AQUIND INTERCONNECTOR

Applicant's Response to Deadline 5 Submissions

Document Ref: 7.9.25

DATE: 23 DECEMBER 2020

APPENDIX 7
TEMPORARY CONSTRUCTION ACCESS TYPICAL LAYOUT DRAWING

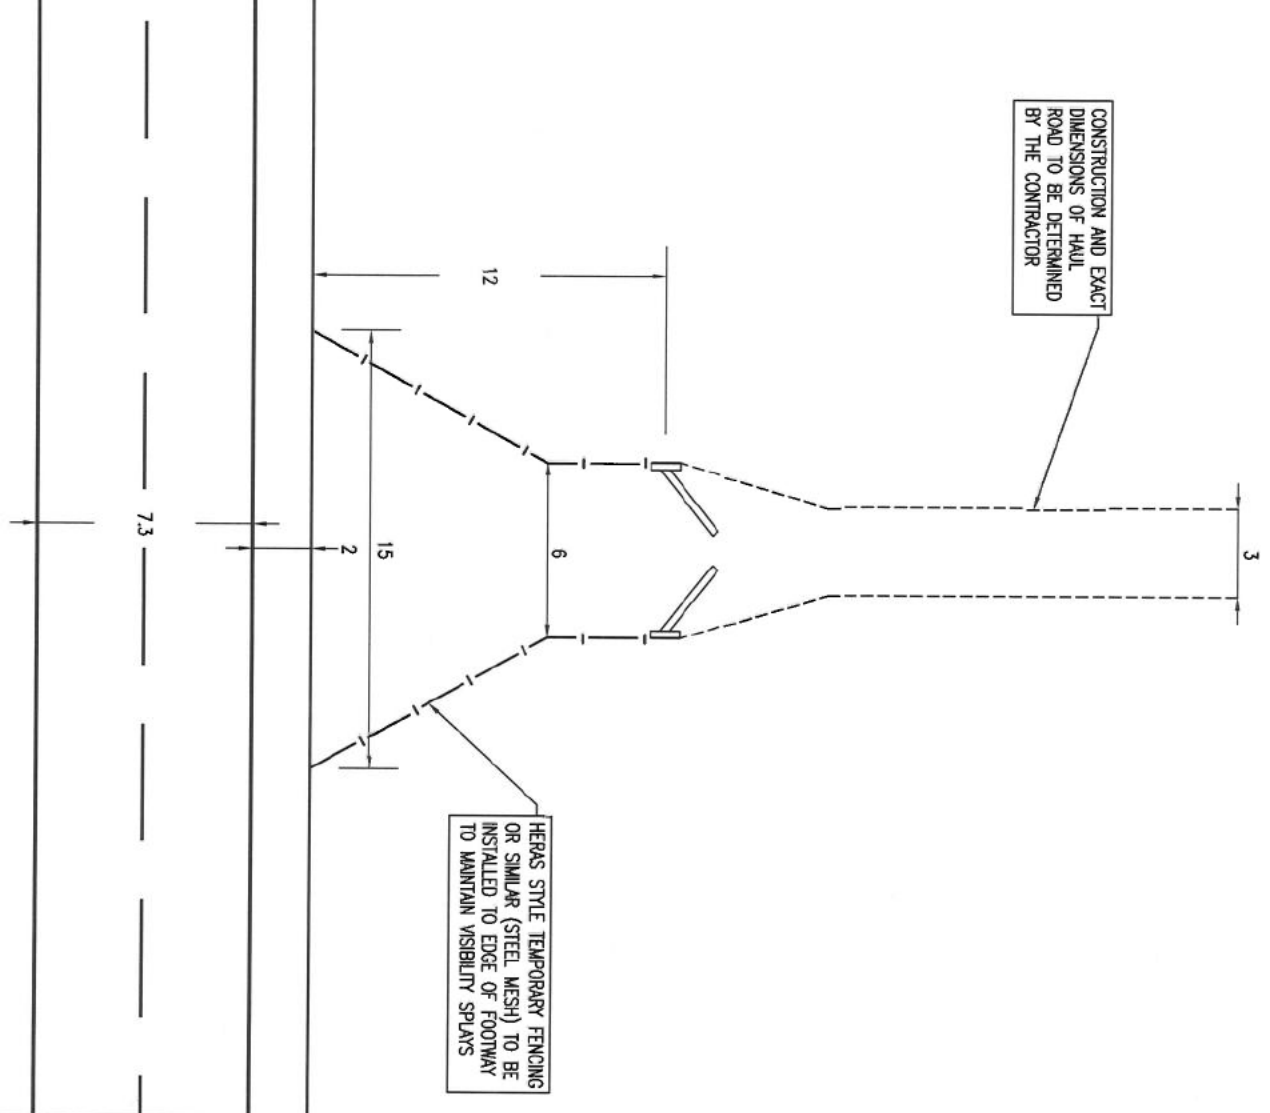
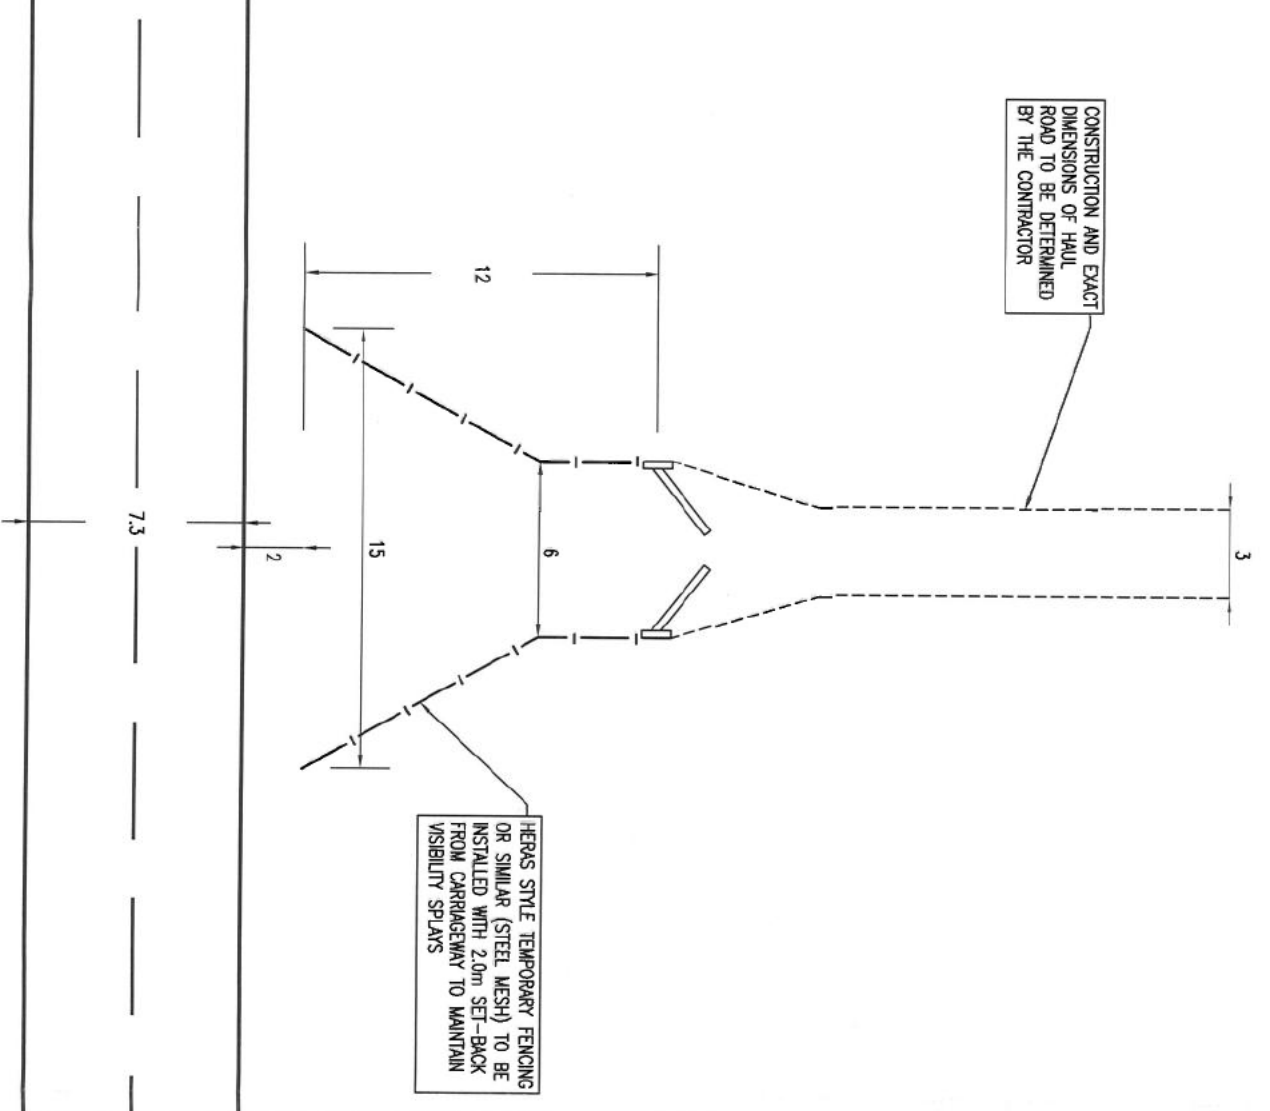
Temporary Construction Accesses	
	<p>The temporary fencing shown in drawing number AQ-UK-DCO-TR-LAY-001 Rev A is proposed to be setback 1 metre from the edge of the highway. To achieve better visibility splays from the accesses, a 2 metre setback should be provided. Any tree or hedgerow removal required to provide the visibility splays will be subject to replacement planting which should be agreed with the relevant Local Planning Authority or the provision of a CAVAT payment commensurate with the cost of the asset if it is owned by the Highway Authority.</p>	<p>As requested by HCC a 2m setback distance between the fencing at the edge of carriageway has now been provided on the temporary construction access drawing AQ-UK-DCO-TR-LAY-001, which has also been updated to reflect comments on access to Anmore Road provided below. This drawing has also been included in Appendix 7 of the updated Framework CTMP submitted at Deadline 6.</p> <p>With regard to replacement of trees and hedgerow Section 1.5.1.4 of the OLBS states that in terms of general landscape and mitigation, planting will be completed to replace hedgerows and trees lost following completion of the construction works. All planting lost shall be replaced with like for like species of a similar size and in agreement with the relevant discharging authority.</p> <p>Specifically in relation to sections of the Onshore Cable Corridor Section 2.3.5 of the OLBS states that mitigation for the loss of hedgerows and hedgerow trees would be replaced with like for like species of a similar size with hedgerow trees repositioned at least 5m away from the Onshore Cable Route within the Order Limits.</p> <p>The Applicant is continuing discussions with HCC and it is agreed in principle that CAVAT payments will be made to mitigate the impacts of the loss of trees in HCC ownership. A development consent obligation is to be progressed between the Applicant and HCC to secure this and other relevant planning obligations.</p>
